Please ask for: Ms Iqraa Malik
Email: iqraa.malik@terraquest.co.uk
Telephone: 01212341390
Our Ref: AL/50/20/HH
Your Ref:
Date: 8th July 2020

Application for Planning Permission for Works or Extension to a Dwelling

Development: Replacement of existing conservatory with new garden room
Location: Limmer Pond Cottage Nyton Road Aldingbourne PO20 3TX

Dwg no:	05 Proposed Elevations
Date:	07.07.20
Drawn:	KAH
Revision:	-

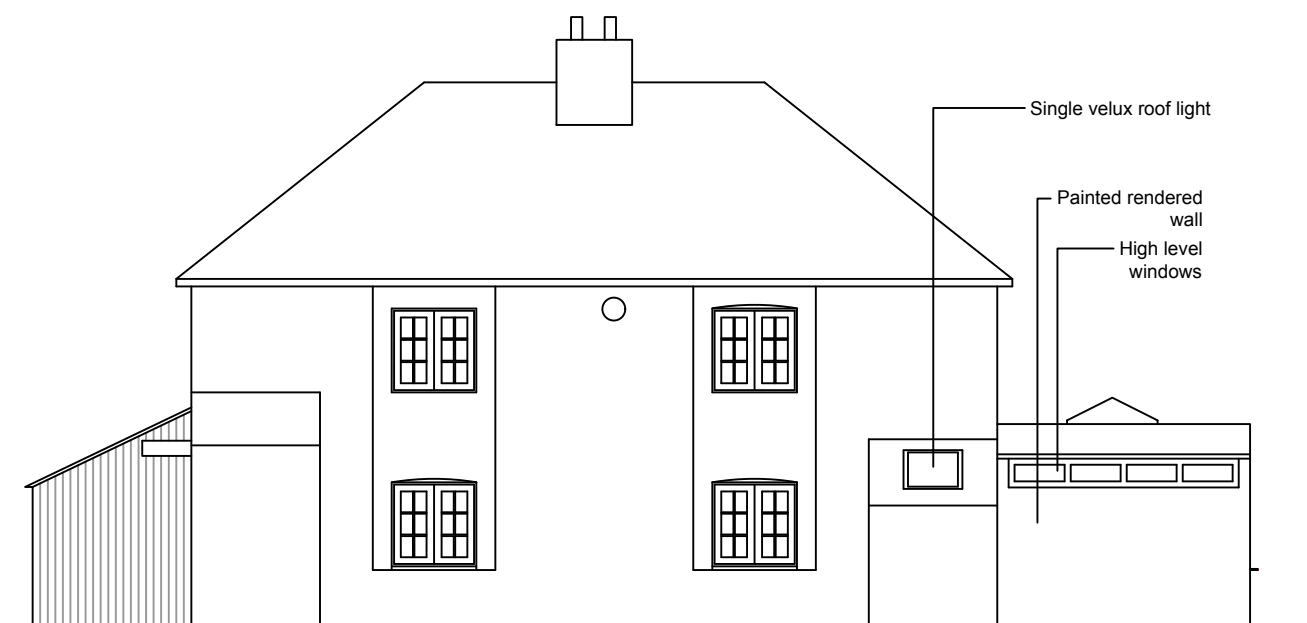
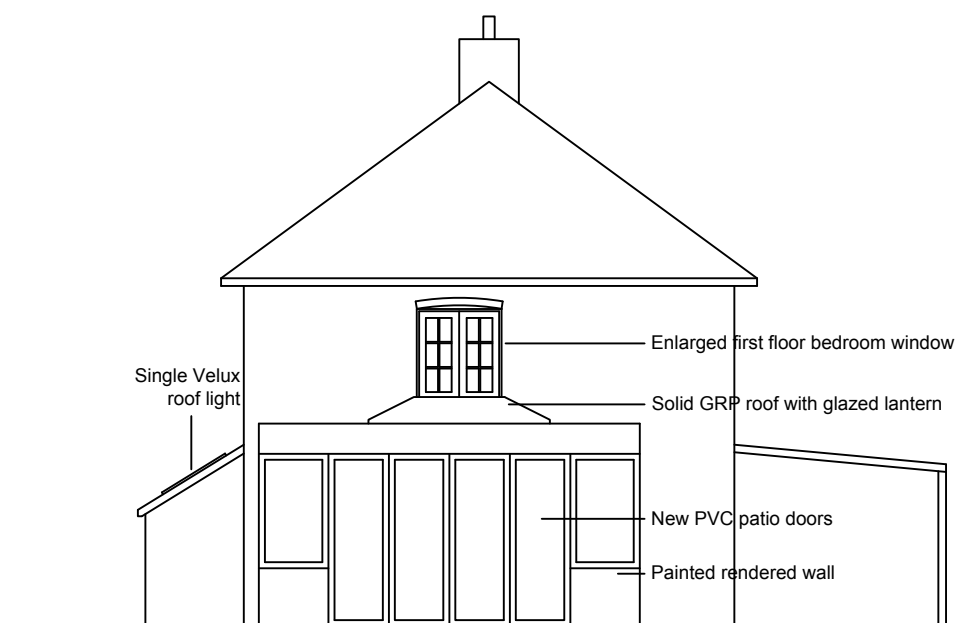
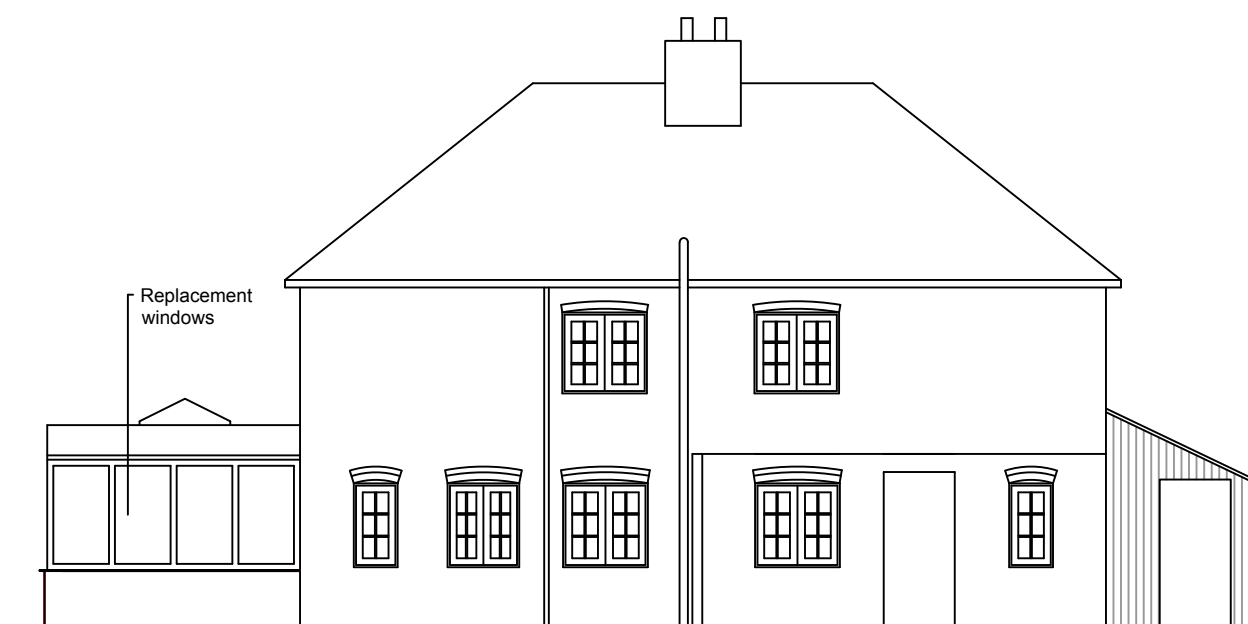
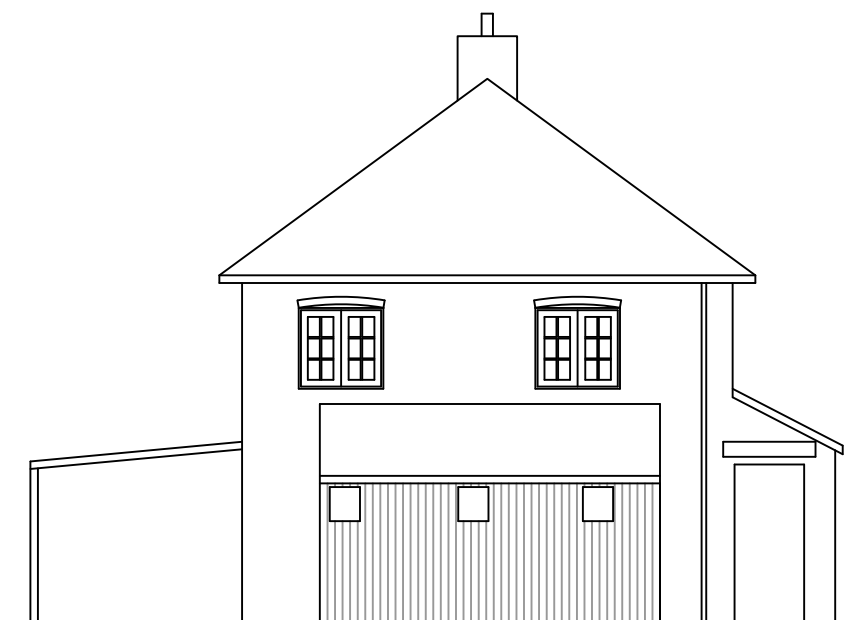
You are required to have clear labels on your existing and proposed elevations. Please amend.

Dwg no:	01 Location and Block Plan
Date:	07.07.20
Drawn:	KAH
Revision:	-

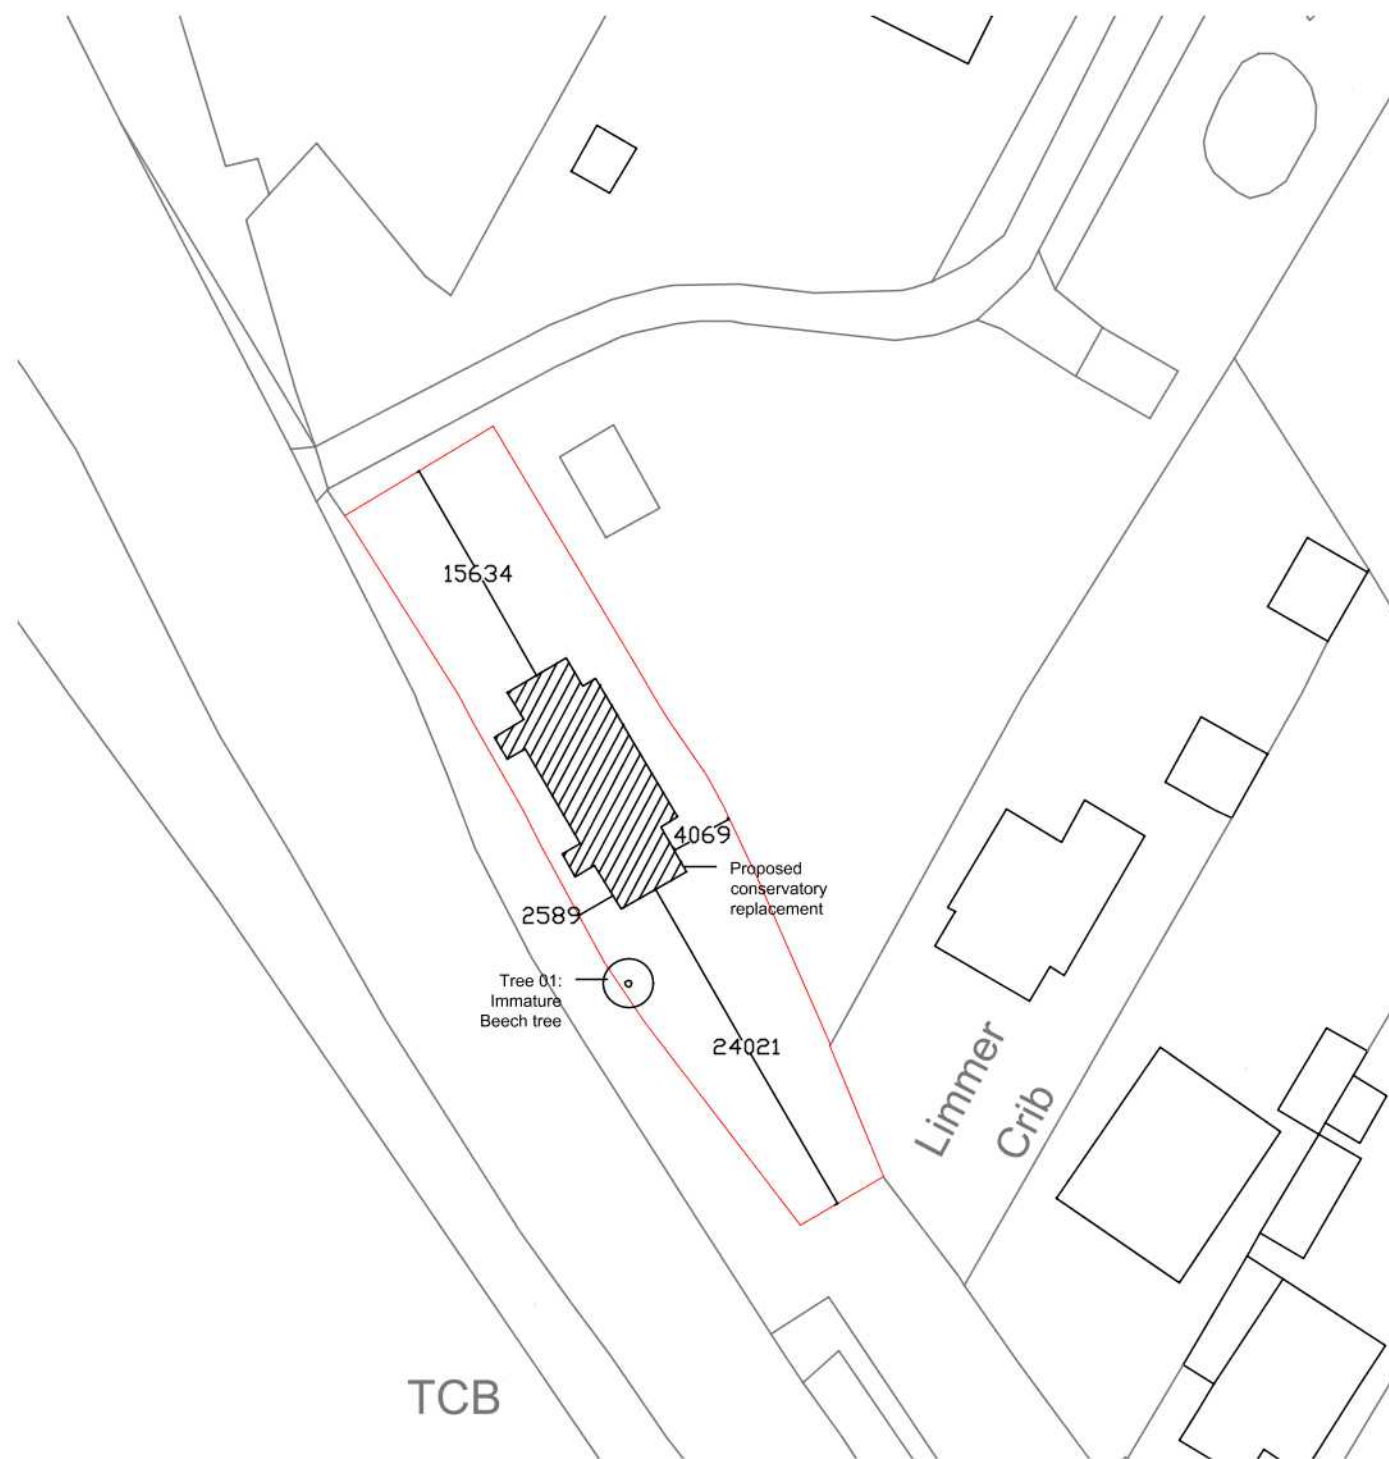
You are required to have a scale bar on all plans. Please add this to your location and block plan. Please amend.

You are required to have dimensions from the proposed extension(s) to all site boundaries. Please amend.

Please confirm your address as you have outlined both 1 and 2 Limmer Cottage on your location plan.

Dwg no:	02 Floorplans
Date:	07.07.20
Drawn:	KAH
Revision:	-

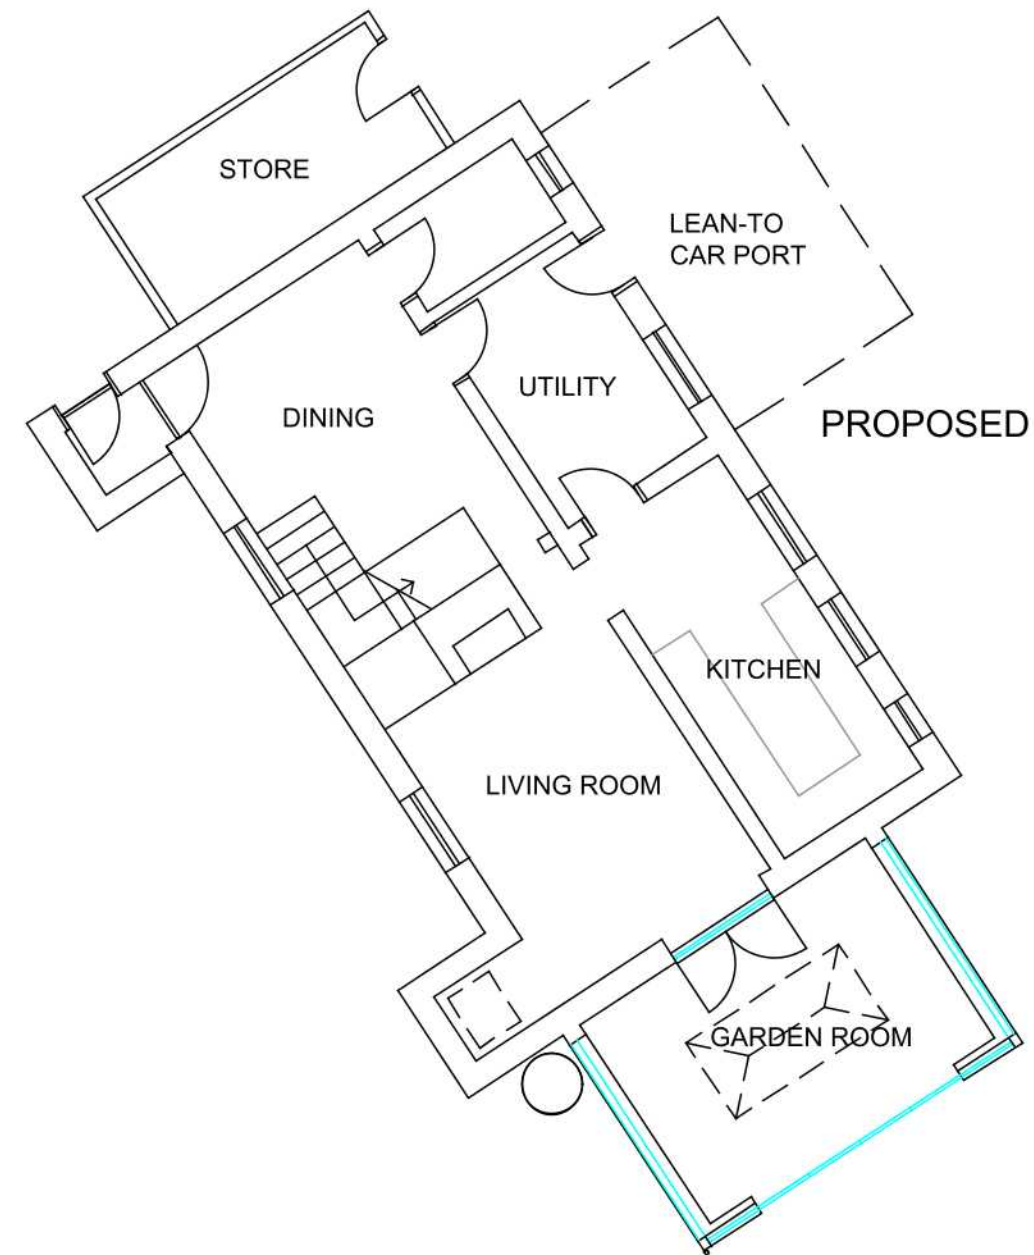
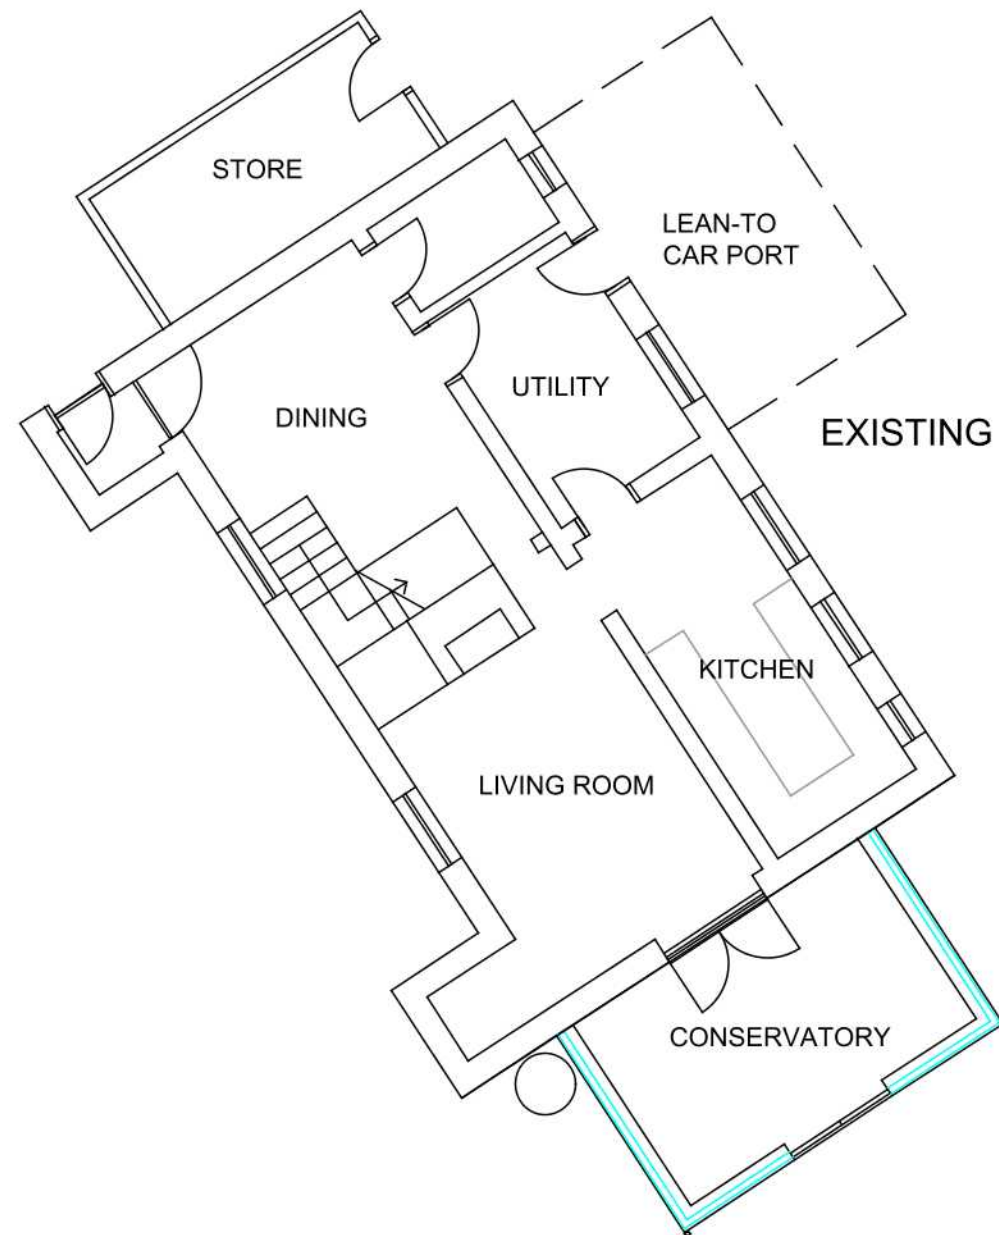
You are required to have clear room labels on all floor plans. Please amend.

Dwg no:	06 First Floor plans
Date:	07.07.20
Drawn:	KAH
Revision:	-

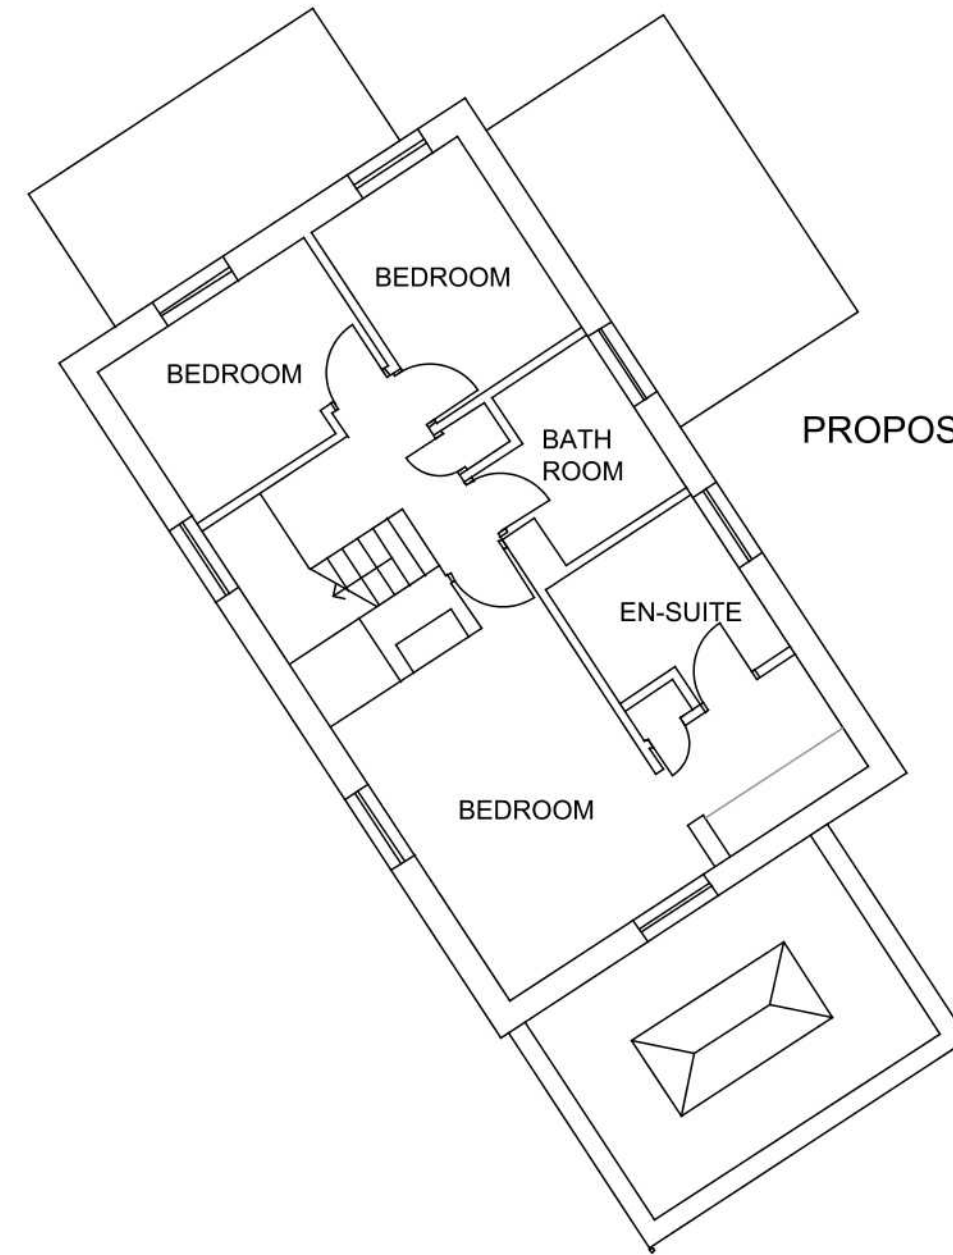
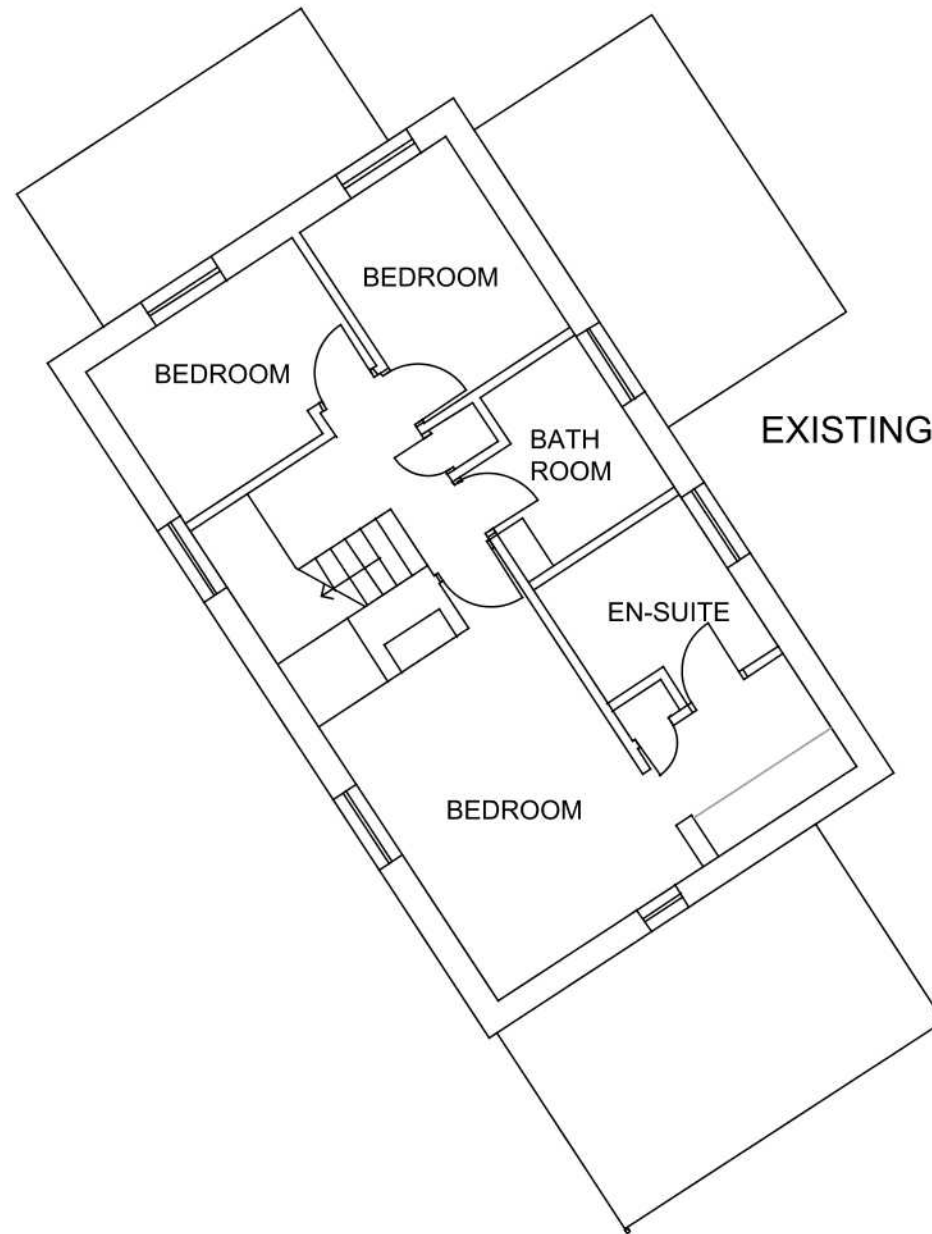
Please submit clearly labelled existing and proposed first floor plans at a scale of 1:50 or 1:100.
